Ribble Valley Borough Council  
Housing & Development Control

Application no: **3/2021/0801**

Address: **Kelvedon Beechthorpe Avenue Waddington BB7 3HT**

Proposal: **Proposed demolition of a single storey kitchen. Construction of 2 storey side extension and single storey rear extension.**

AMENDED
PROPOSED SITE
PLAN

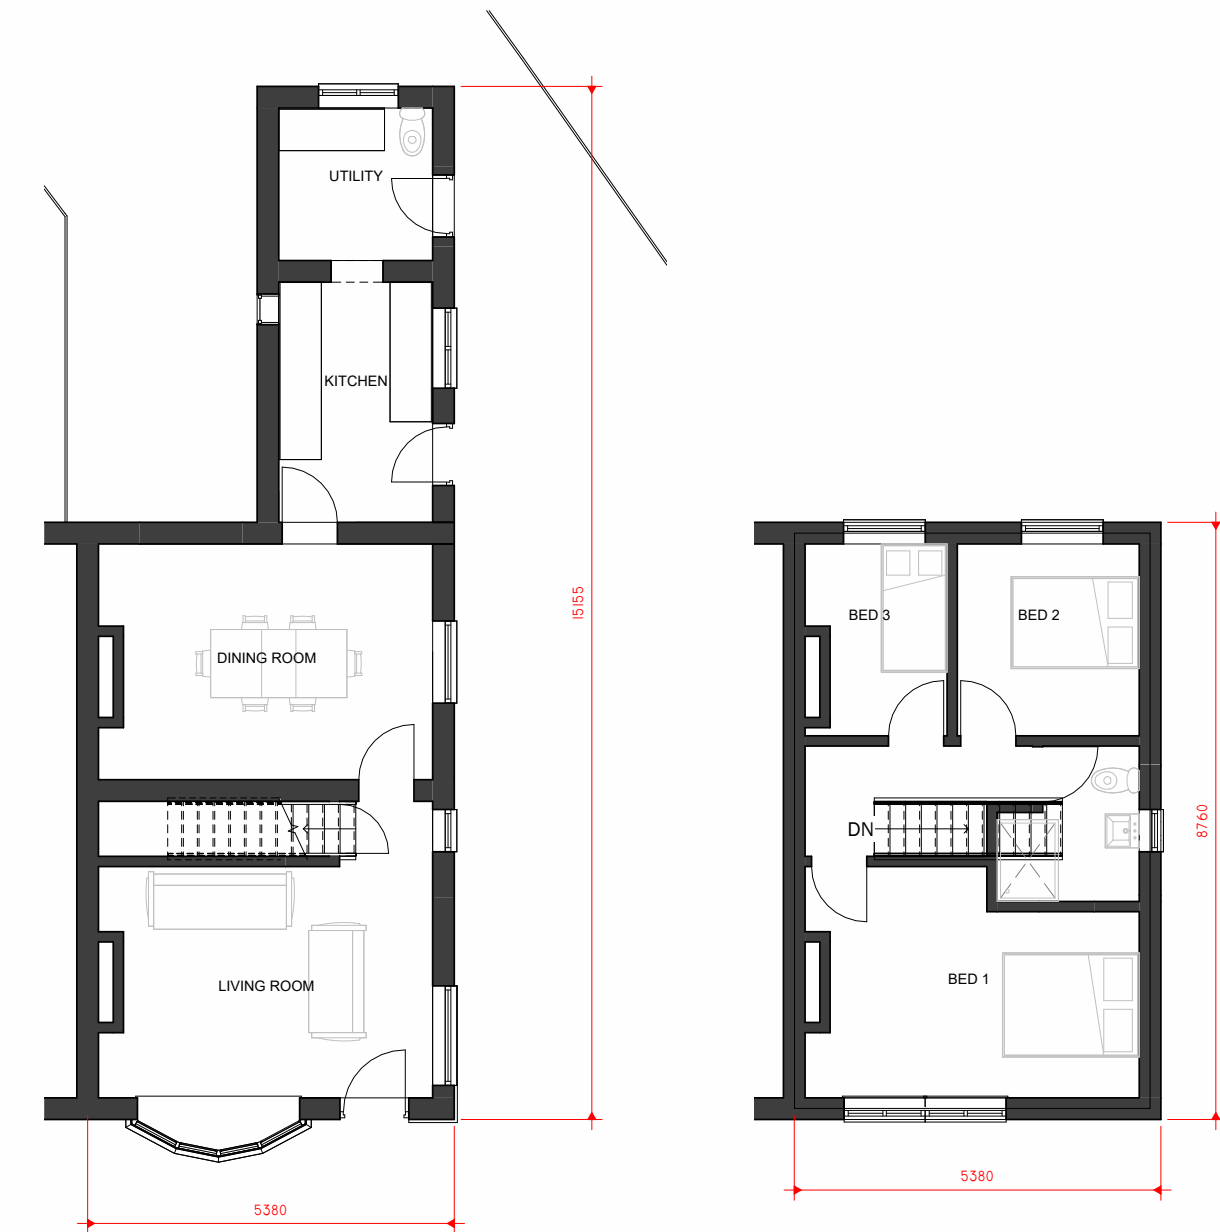
The LHA have now reviewed Peter Hitchen drawing number A1.2 titled "Amended Proposed Site Plan," and are satisfied that the access arrangements and the driveway length complies with the LHAs guidance and so the LHA have no objection to the proposal.

The LHA have reviewed Peter Hitchen drawing number A1.2 titled "Amended Proposed Site Plan," and understands that the site will provide 2 car parking spaces for the proposed 4 bed dwelling.

This does not comply with the Joint Lancashire Structure Plan which requires a 4-bed dwelling to provide 3 car parking spaces. Therefore, there is a shortfall in one car parking space.

Notwithstanding this, the LHA will accept the shortfall in parking in this case. This is because there appears to be adequate space for on-street parking and whilst this is not ideal the LHA would not advise refusal of an application based on a shortfall of one parking space when compared to the existing situation.

1. No part of the development hereby permitted shall be occupied until such time as the access arrangements shown on Peter Hitchen drawing number A1.2 titled "Amended Proposed Site Plan" have been implemented in full.

3. The development hereby permitted shall not be occupied until such time as the parking and turning facilities have been implemented in accordance with Peter Hitchen drawing number A1.2 titled "Amended Proposed Site Plan". Thereafter the onsite parking provision shall be so maintained in perpetuity.
